Ribble Valley Borough Council
Housing & Development Control

Application no: **3/2022/1038**

Address: **Land at the corner of Moorgate Lane and Kenyon Lane Dinckley BB6 8AN**

Proposal: **Proposed development of a holiday cottage.**

Proposed Site Plan - 1:200

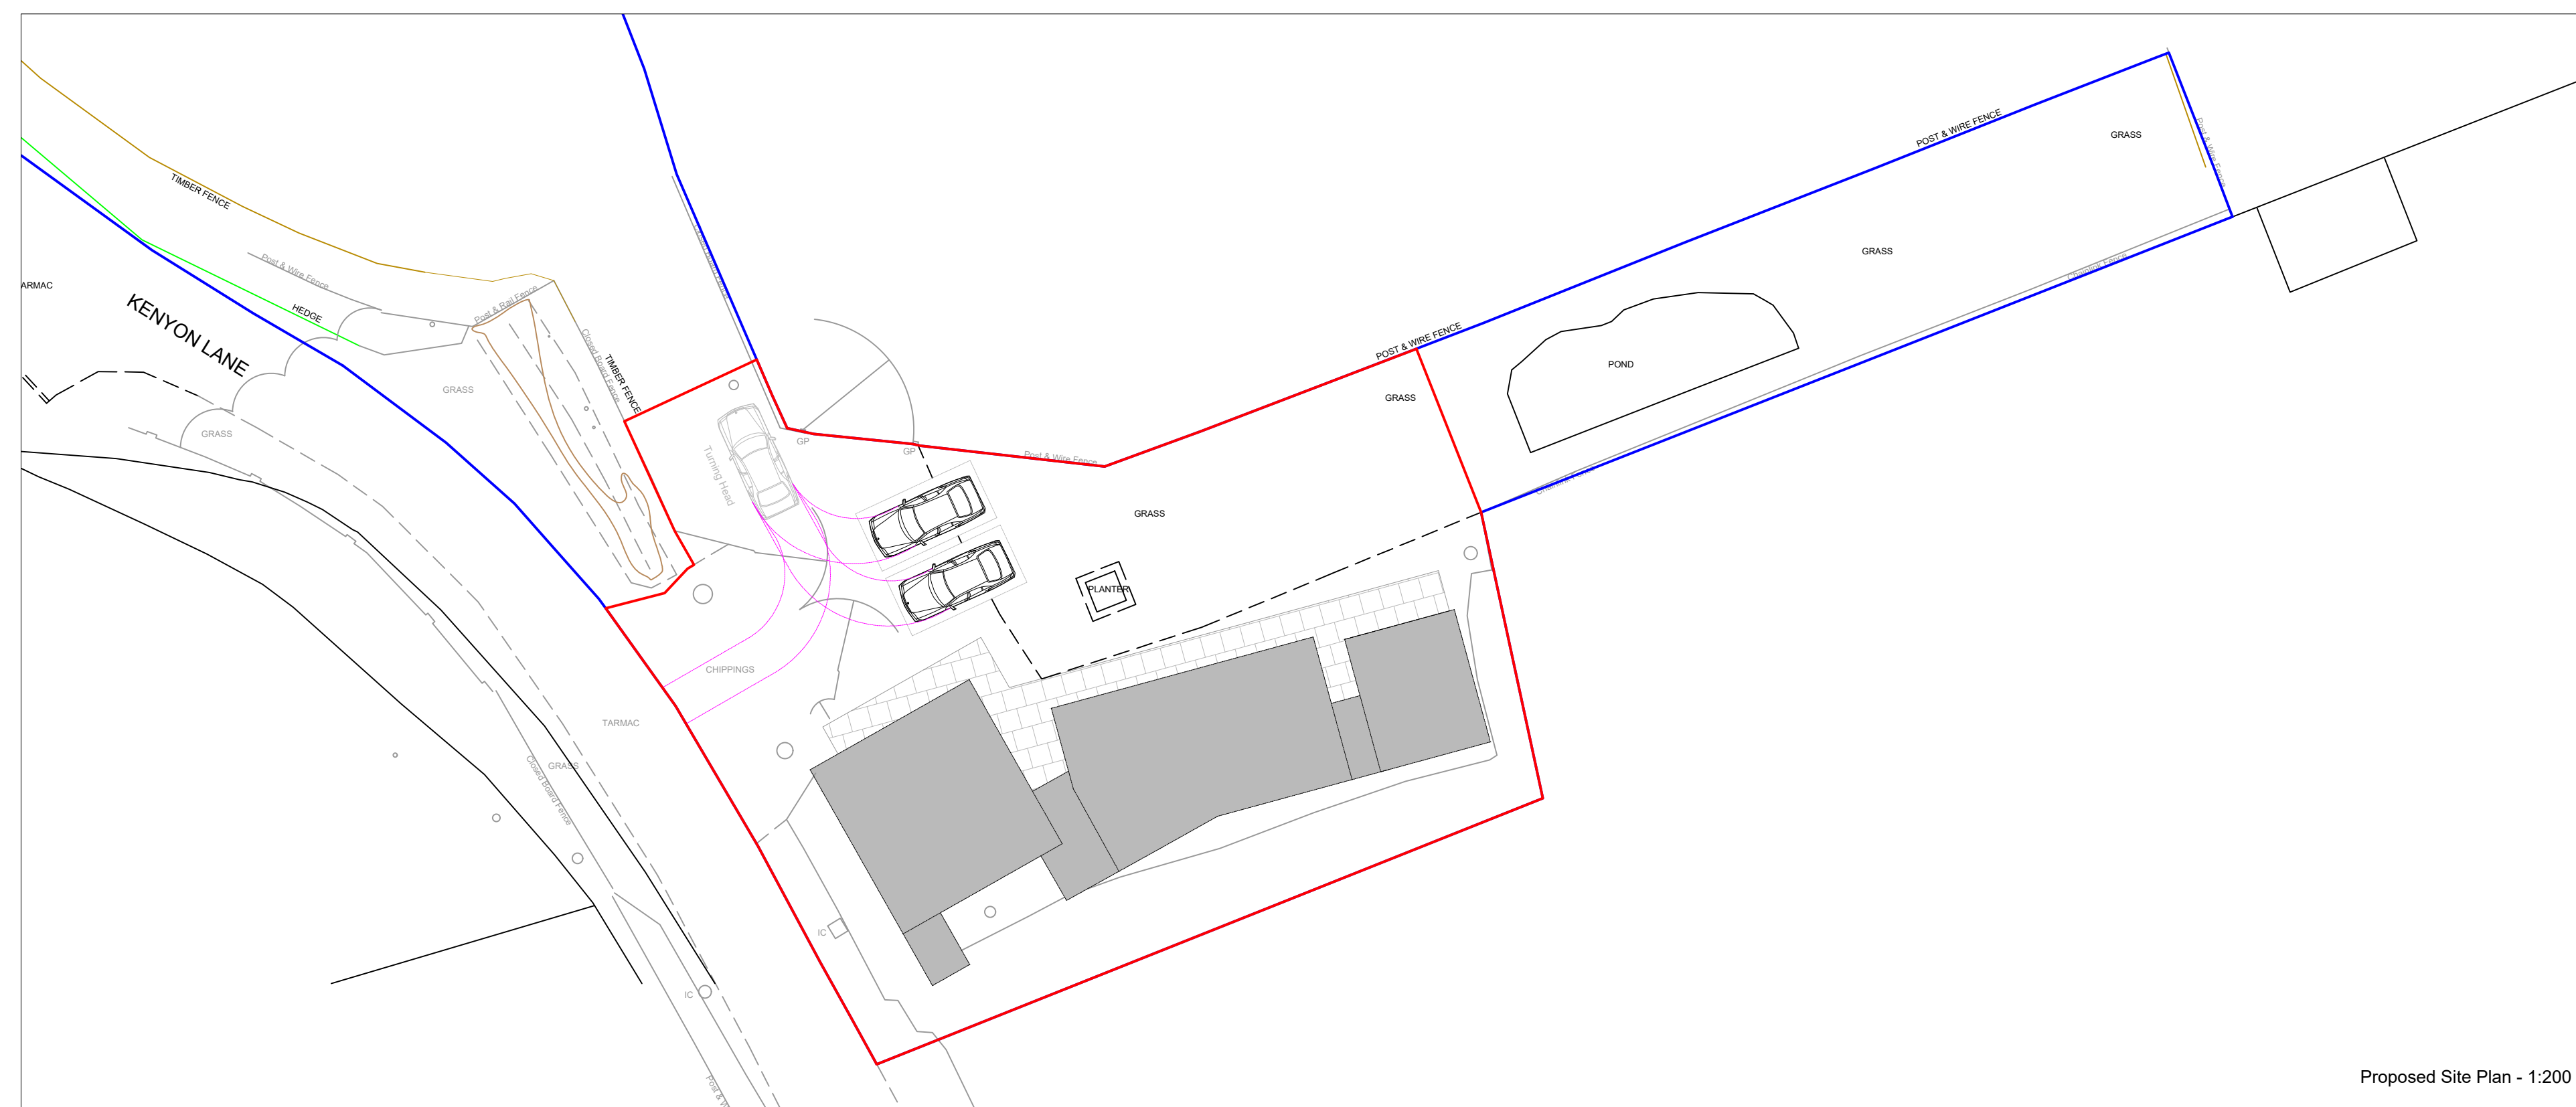
However, the LHA require a site access drawing to be submitted showing that the access can provide visibility splays of 2m x 43m in both directions. This is because following the proposal, the access is likely to generate more traffic and in turn be intensified. Therefore, the LHA require the minimum visibility splays to be provided or should the access not be able to achieve the visibility splays, a traffic survey should be undertaken demonstrating the 85th percentile speeds along Kenyon Lane within the vicinity of the site access.

The LHA are aware that the proposed turning head for the site is located a short distance away from the gated access. Therefore, turning around internally to enable vehicles to leave the site in a forward gear may not be possible due to there being a potential conflict with the gate. As a result of this, the LHA advise the Agent to relocate the car parking spaces to enable turning to occur internally.

The LHA remind the Agent that the recommended reversing space from a car parking space is 6m.
